From: Buttery, Lucy
Sent: 03 April 2019 12:10
To: _planningadvice
Subject: H17-0149-19 - AMENDMENT 1 (Land adj. 72 Station Road, Surfleet)
Attachments: Mimecast Attachment Protection Instructions; Amend form.pdf; Proposed Site Layout Revised.pdf

H17-0149-19 – 1AMEND and 1AMFORM

BLOCK & LOCATION PLAN	
Scale 1:200 1:2500 @A1	Drawing No. 1815-01-A
Date. JAN. 19	Drawn. J.C.

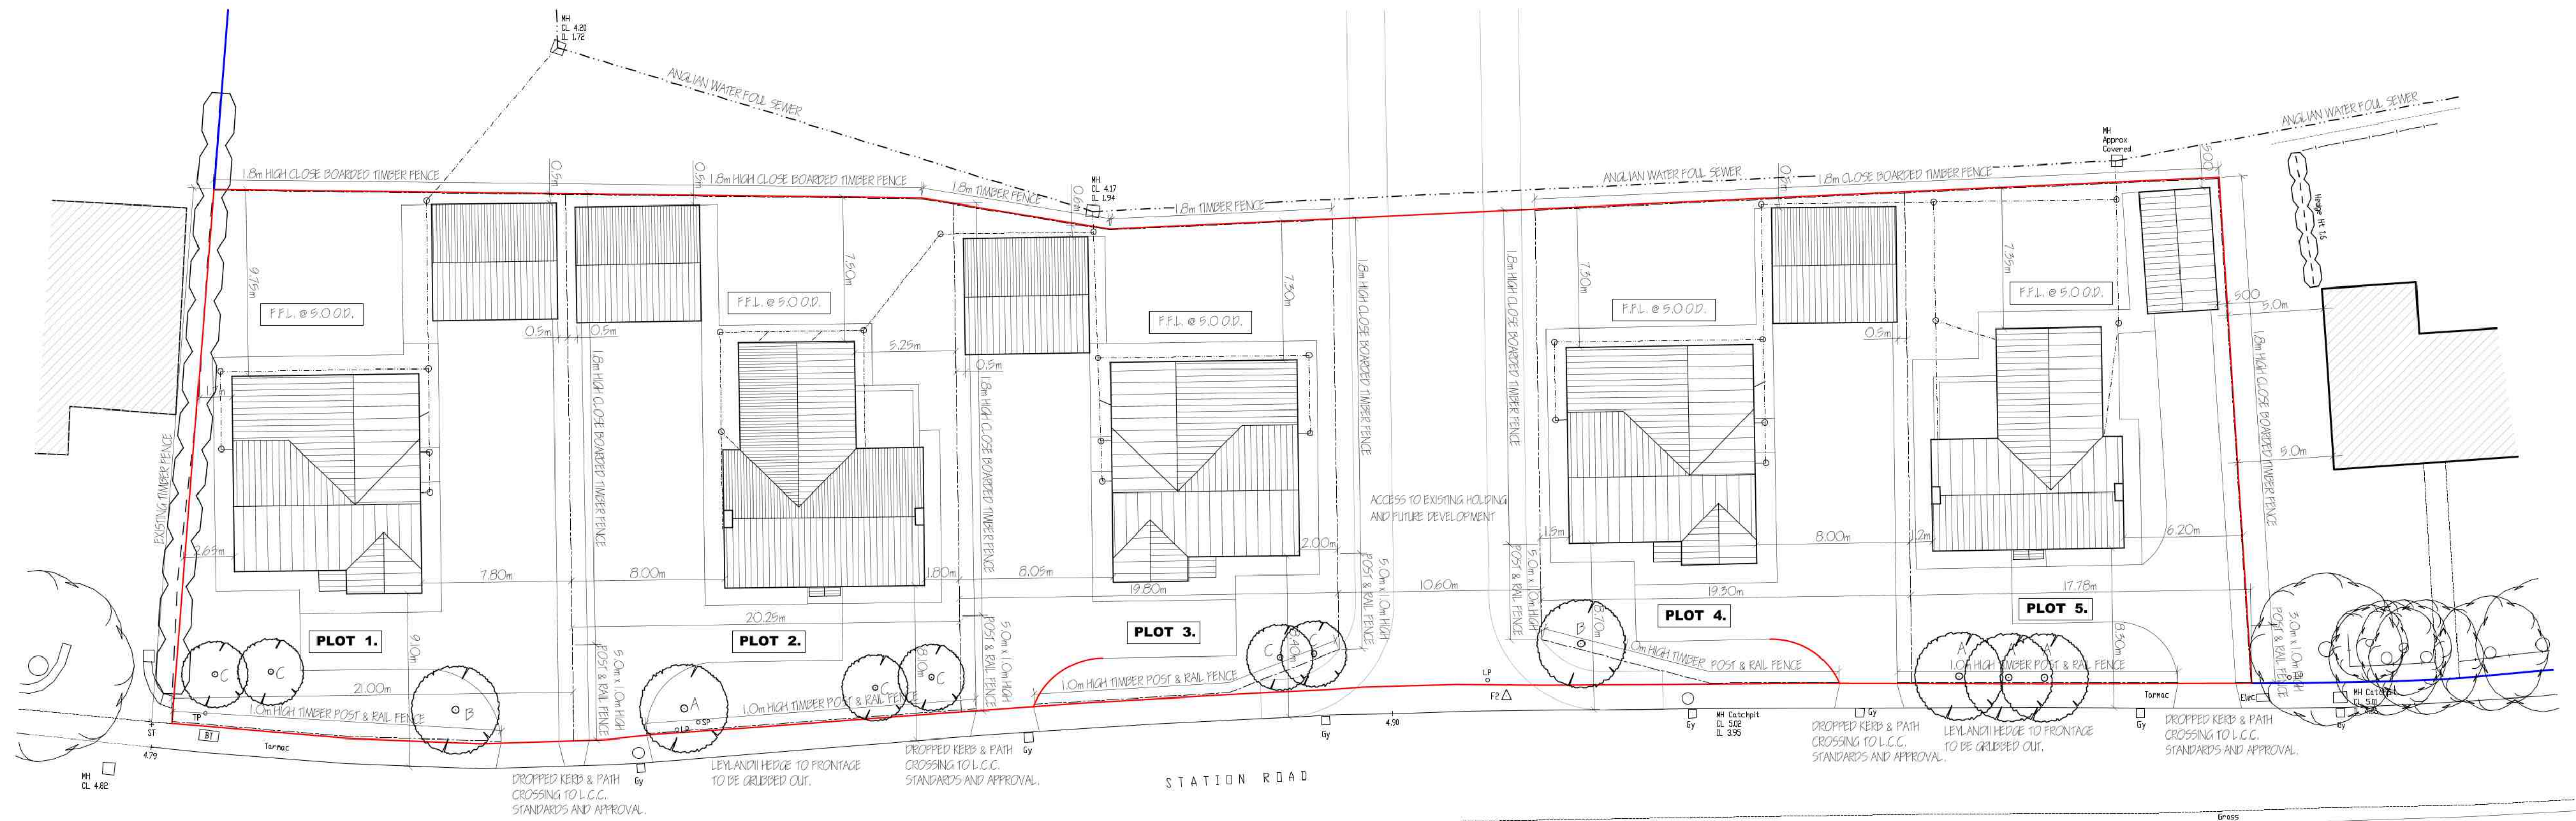
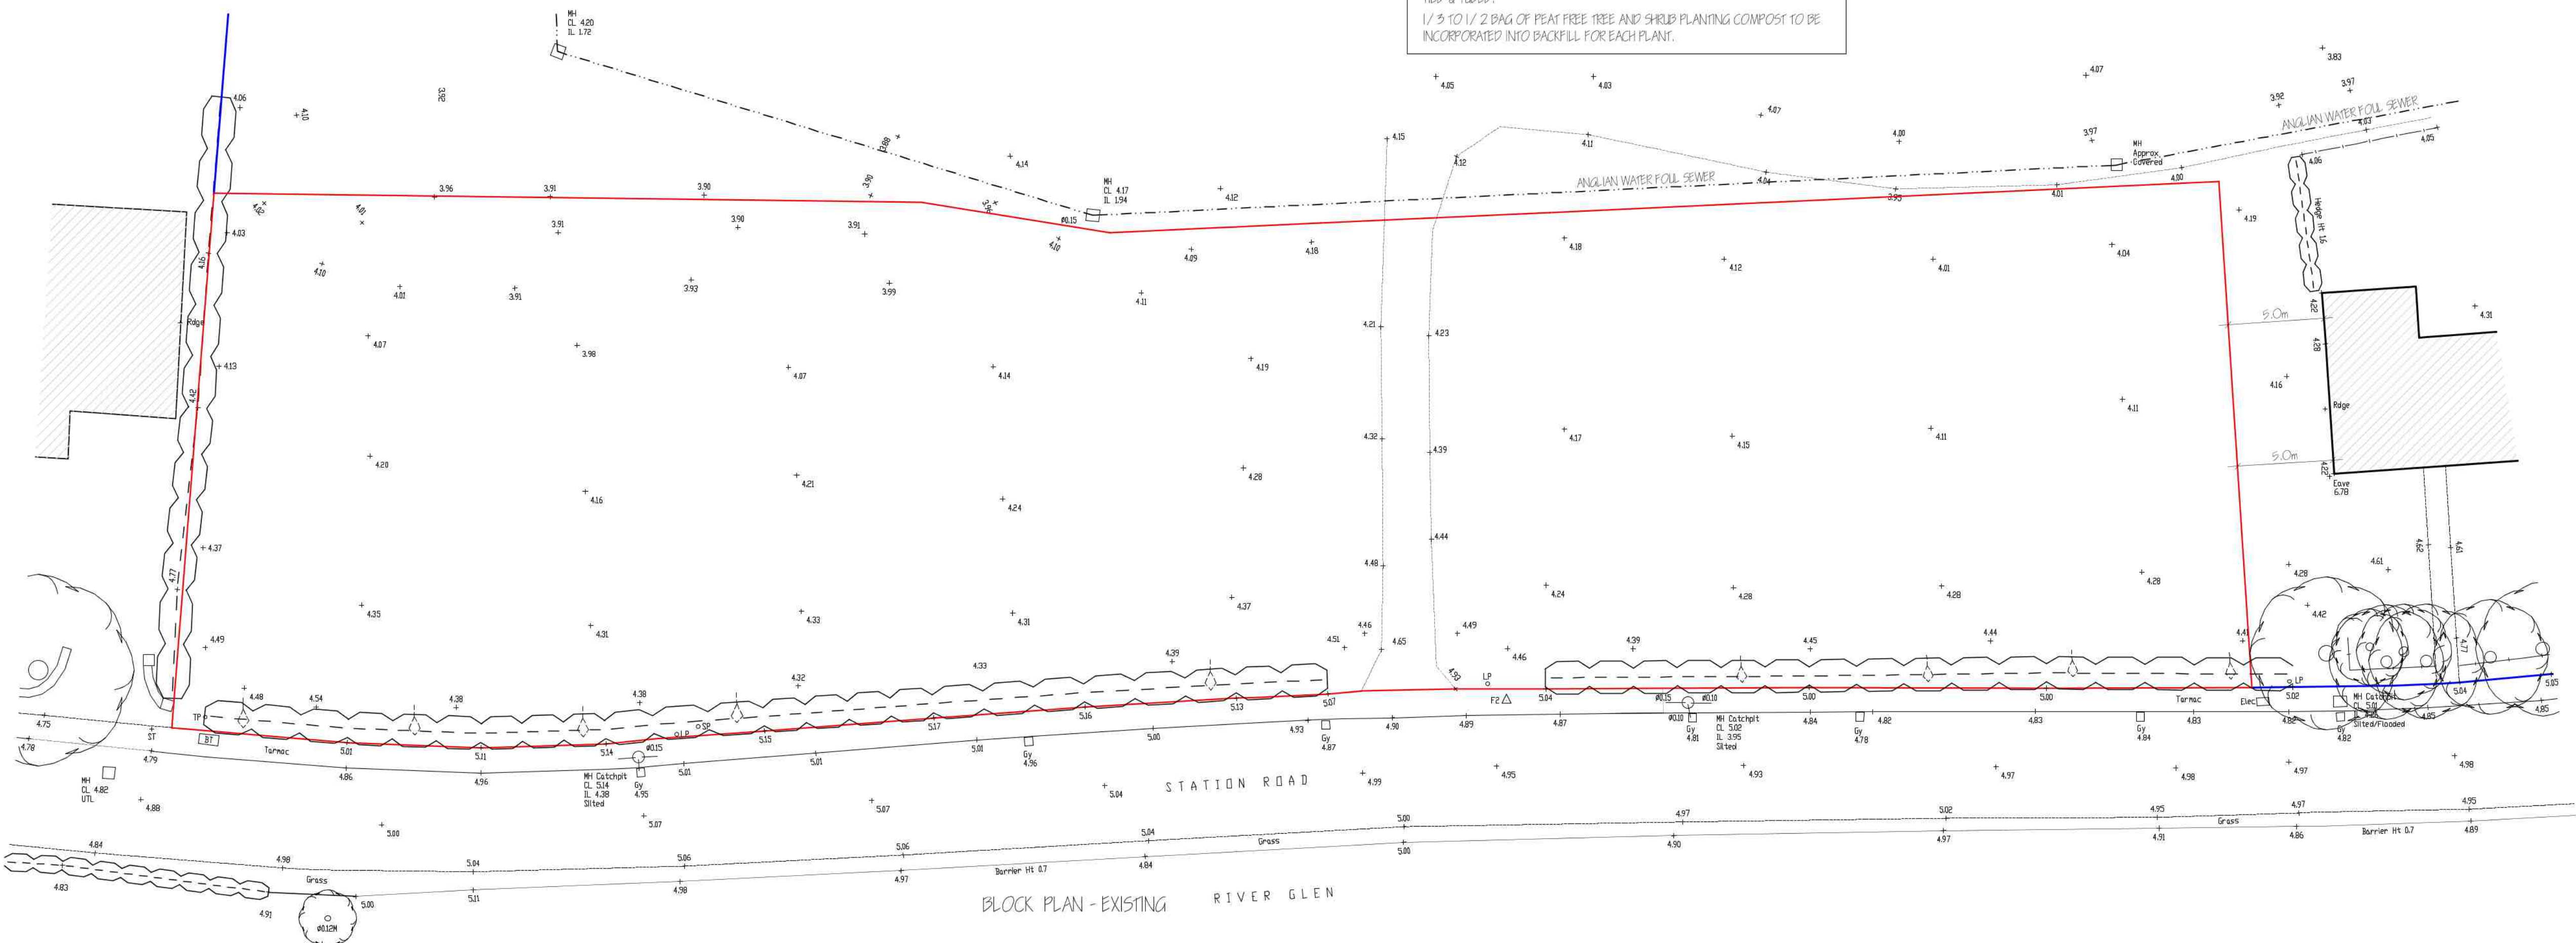
For clarity it would be preferable if you could send through amended plans with the revised FFLs on.

Also, it does not appear that FFL's of 4.6 OD are sufficient given the site levels shown on the topographical plan and the requirement for FFL's to be raised by 500mm. **AS RECOMMENDED IN THE FRA THE FFLs SHALL BE SET TO AT A MINIMUM OF 500MM ABOVE EXISTING SITE LEVELS. IS THIS SUFFICIENT OR WOULD YOU LIKE US TO AMEND THE PLANS ACCORDINGLY?**
